RE: Comments dated August 5, 2019

SUBJECT: Forest Lakes Drive cost recovery comments

Engineering Division

DETAIL MAP 1 - Landscape Plan

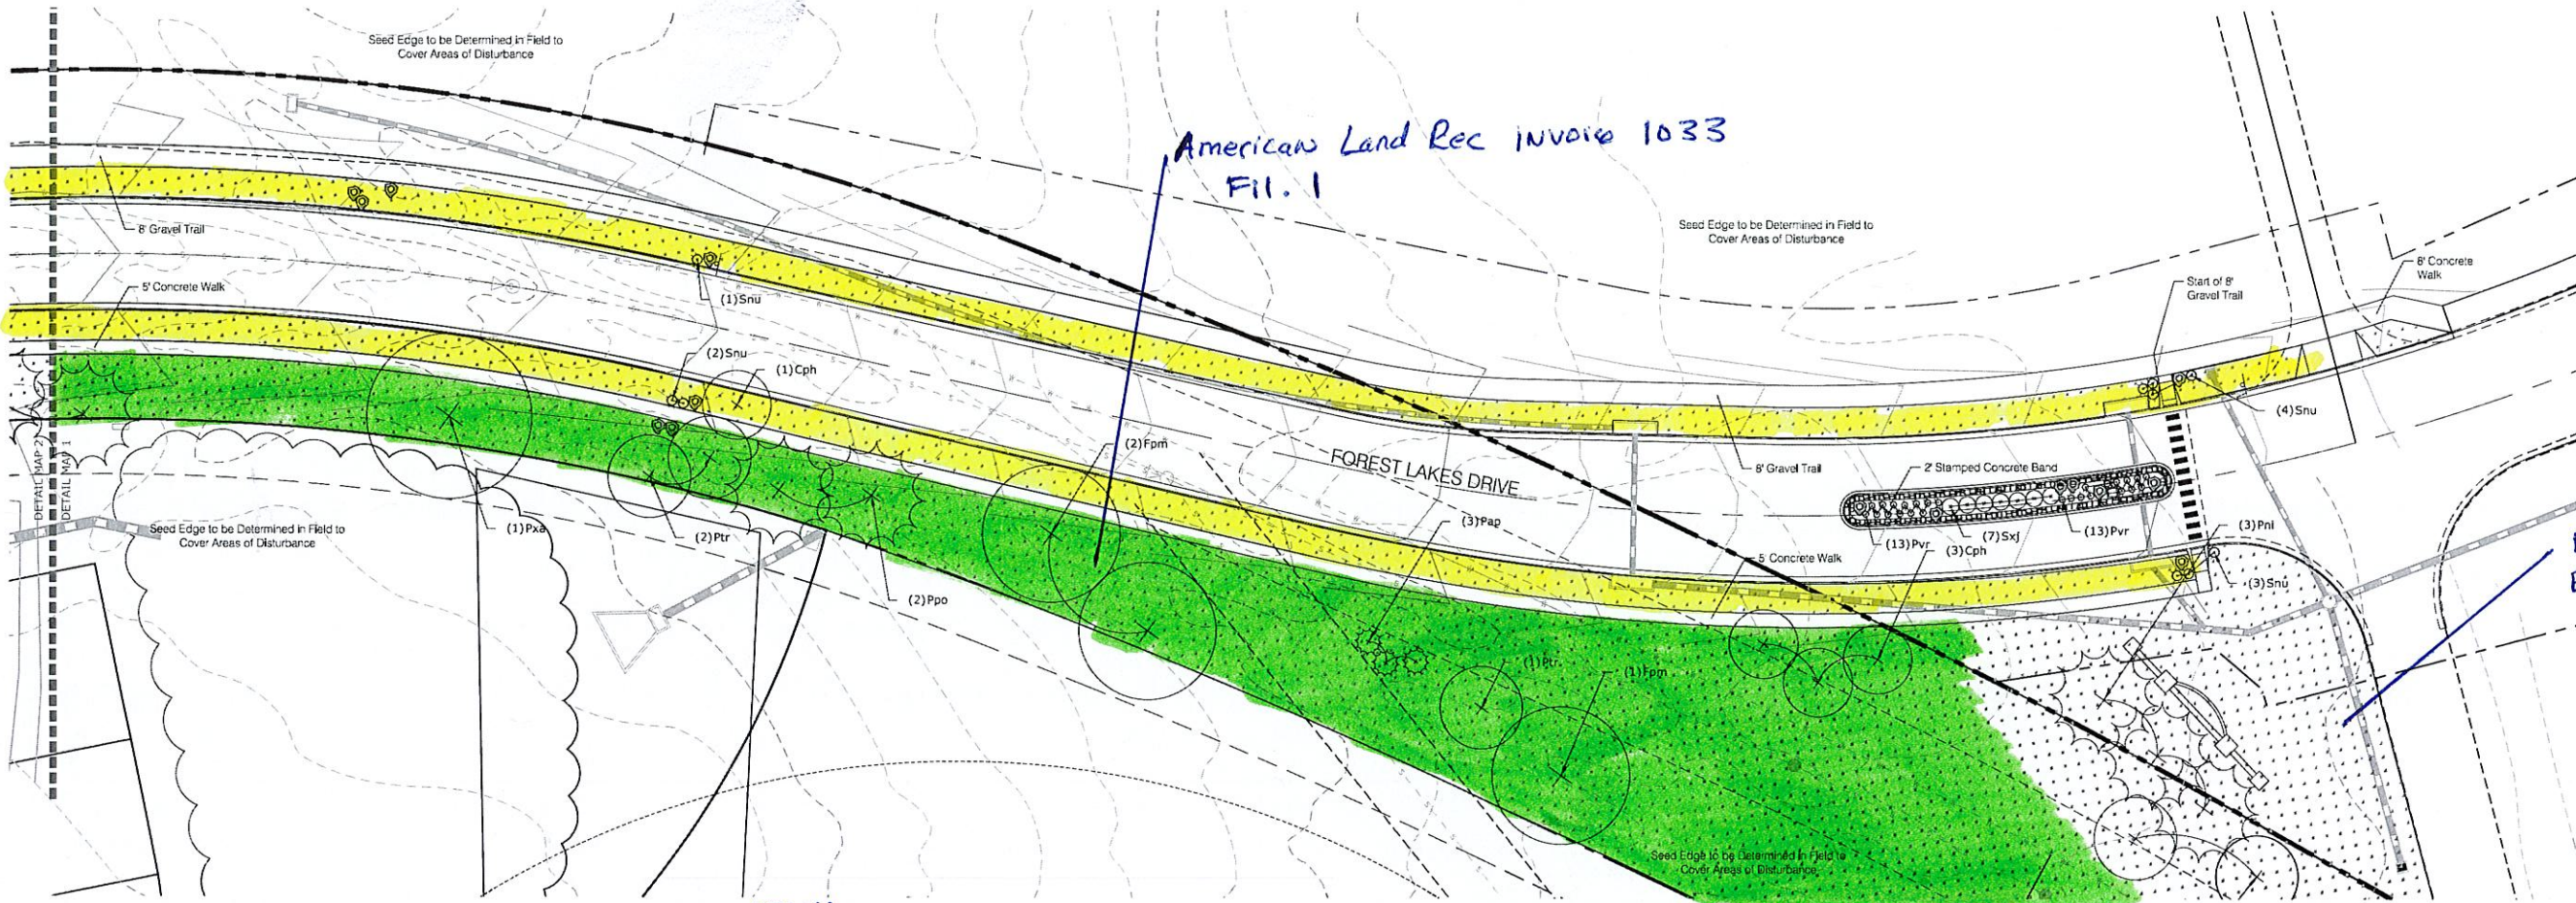
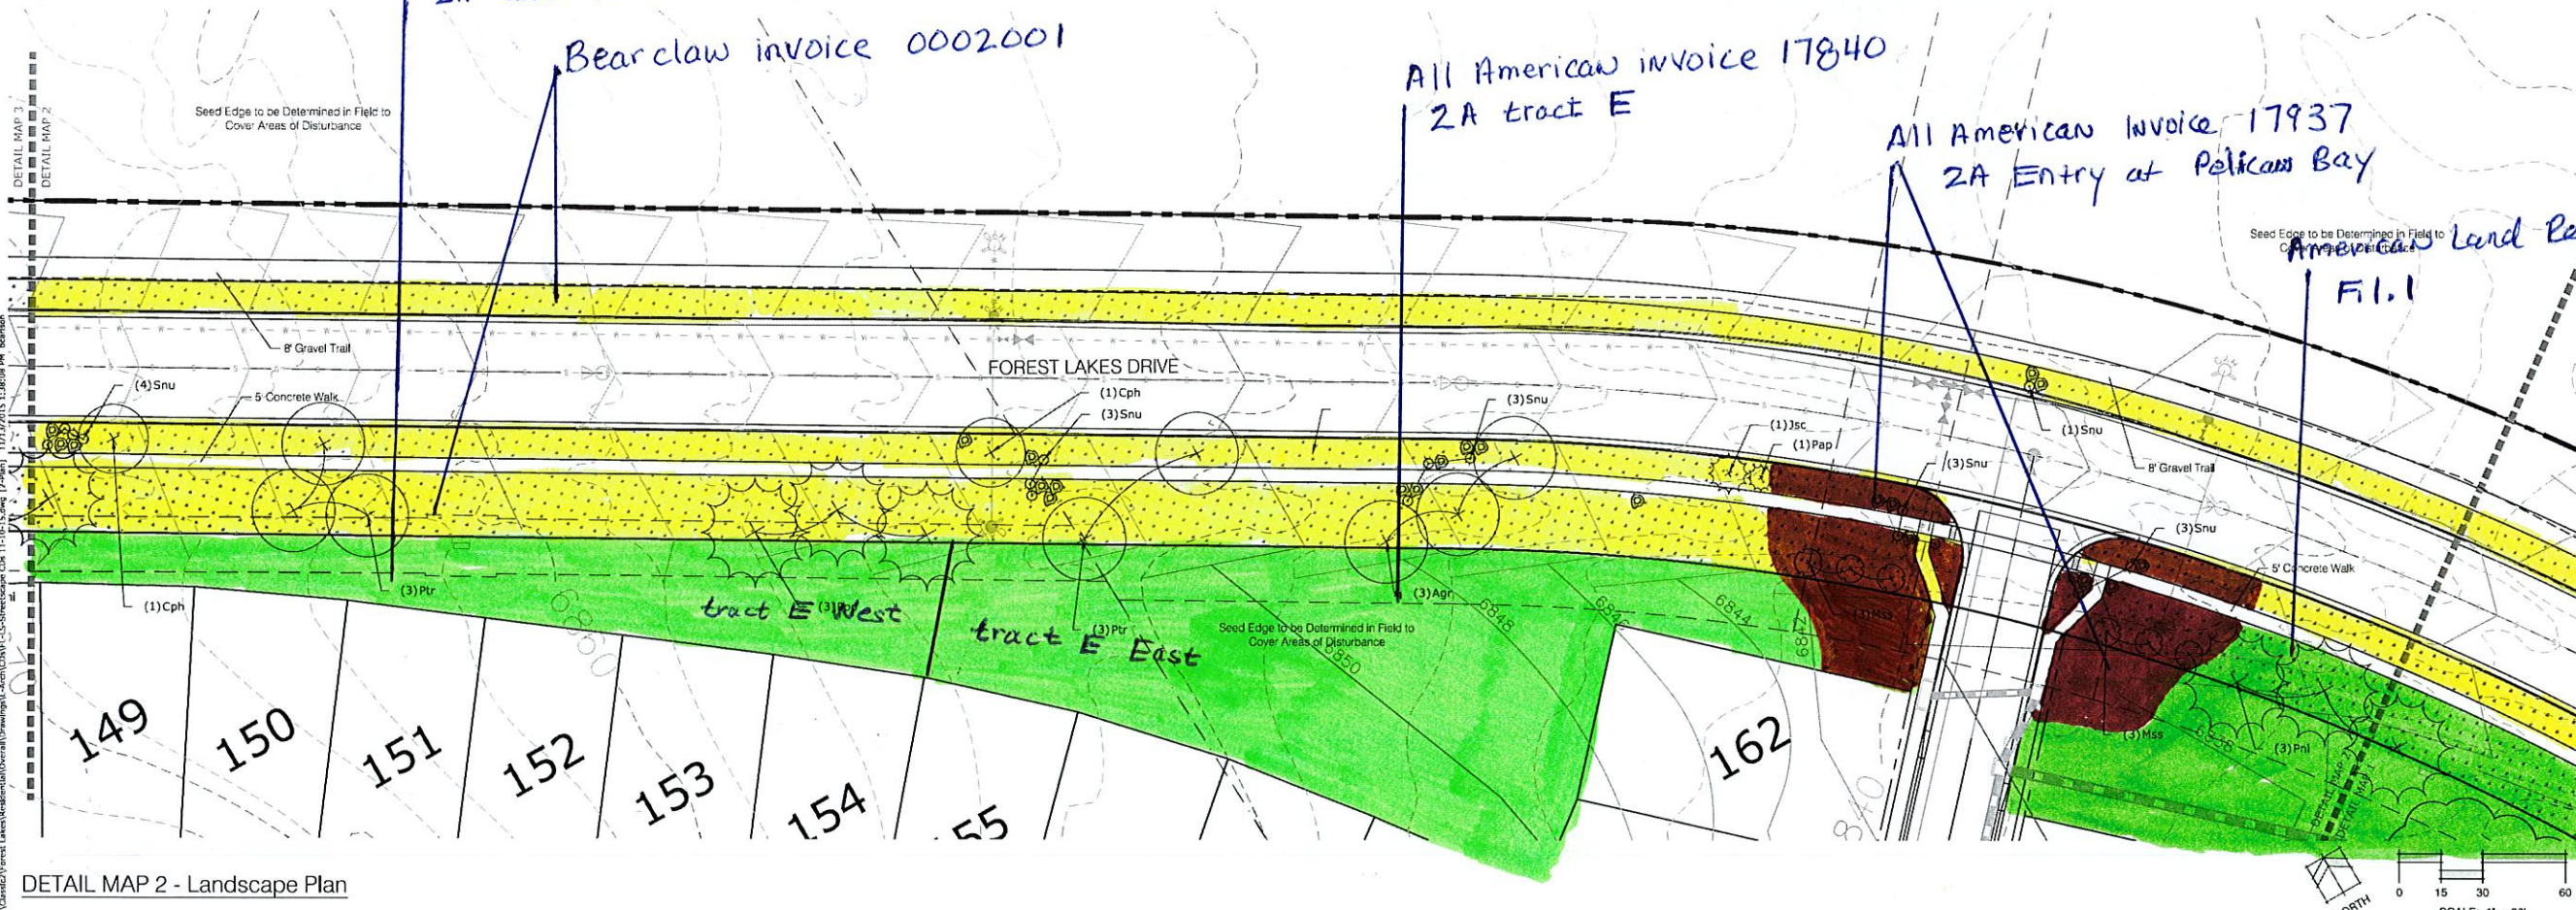
4. Please add sheet 2 of 7 of the landscape plan to show the area of the monument sign that is not included in this recovery request.

Response: We have added sheet 2 of 7 that shows the area of the monument signage and landscape that was not part of the requested cost recovery.

## Forest Lakes Dr. Cost Recovery Exhibit

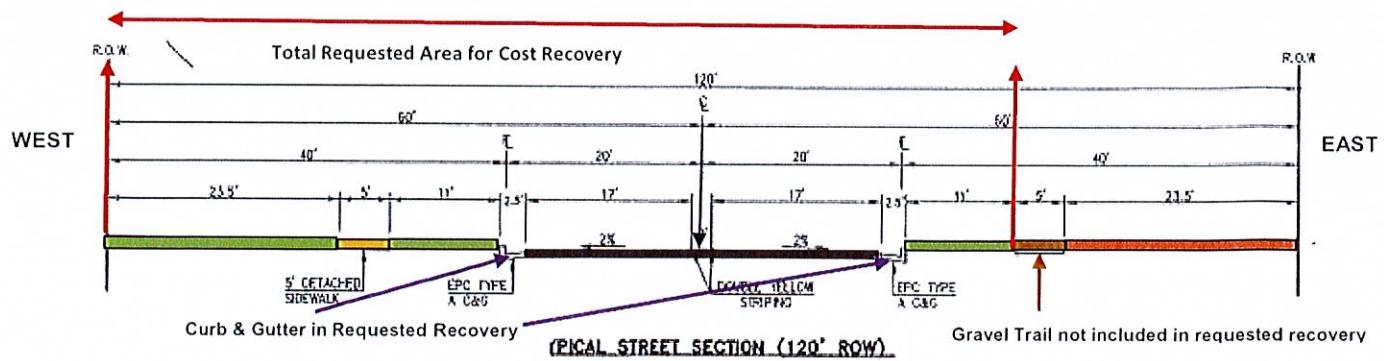
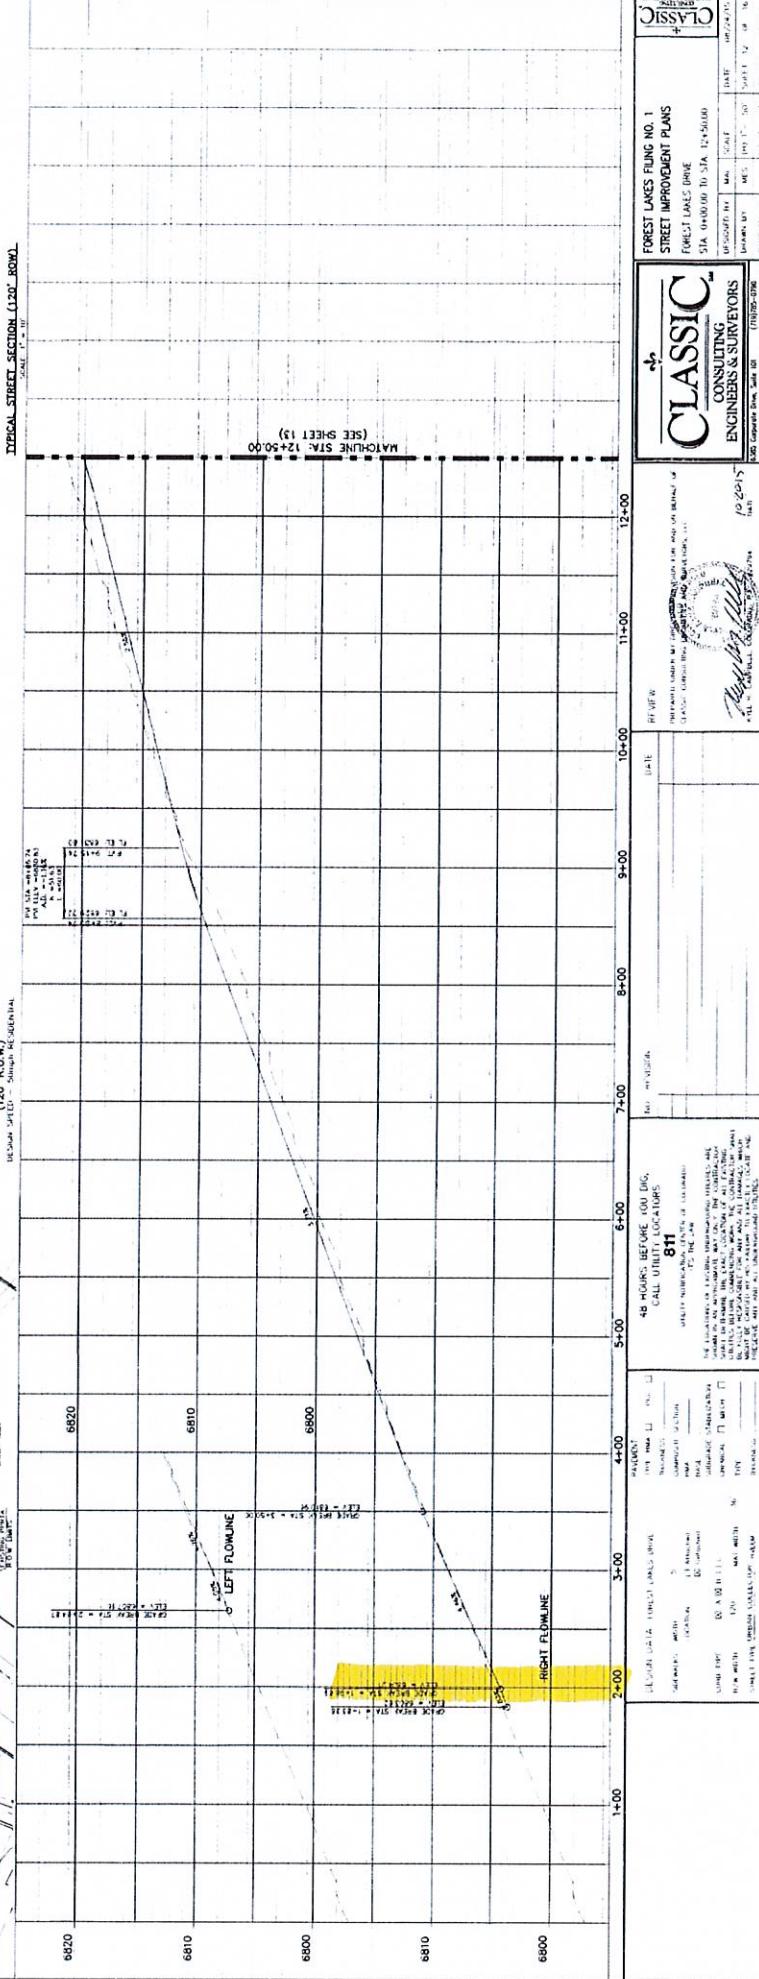
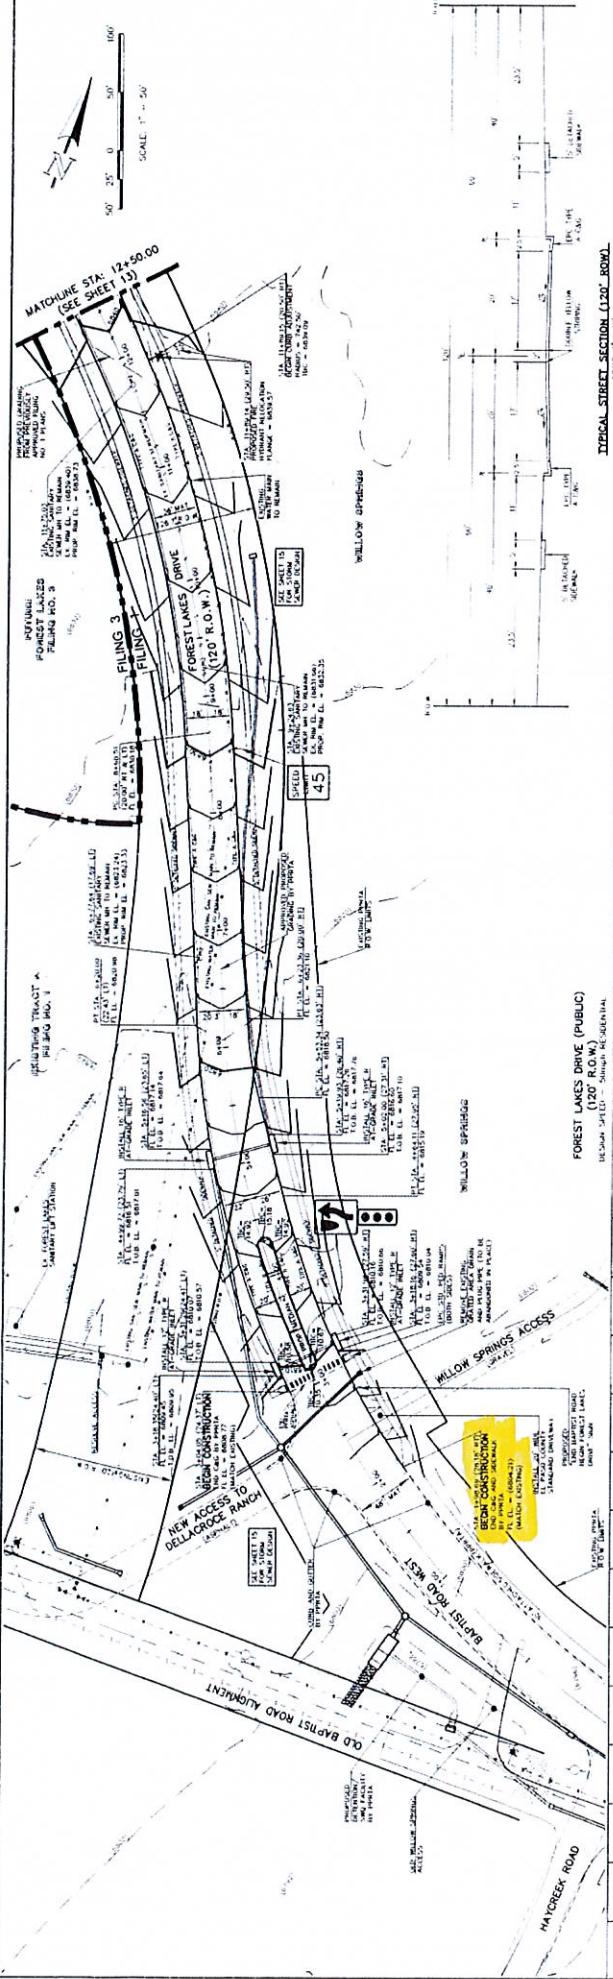
5. Please add the following information to the section view provided for clarity of what was constructed and the extend of the recovery:

- a. Legend for colors
- b. Title and line delineating the extent of the recoverable (i.e. at the landscaped park strip and the road base trail on the east or north side of the street)
- c. Please correct that the sidewalk on the east side of the road was actually constructed as road base. Although this is not a part of the recovery, it will allow one to quickly identify the direction of the section view.
- d. Title
- e. Delineate area of deciduous vs transplanted trees.

Response: We have created a new exhibit with the noted additions. We added a legend for colors, a title and a delineation of the requested recovery area, we have noted that the sidewalk on the east side of Forest Lakes Drive is constructed of gravel and that it is not part of the requested recovery.
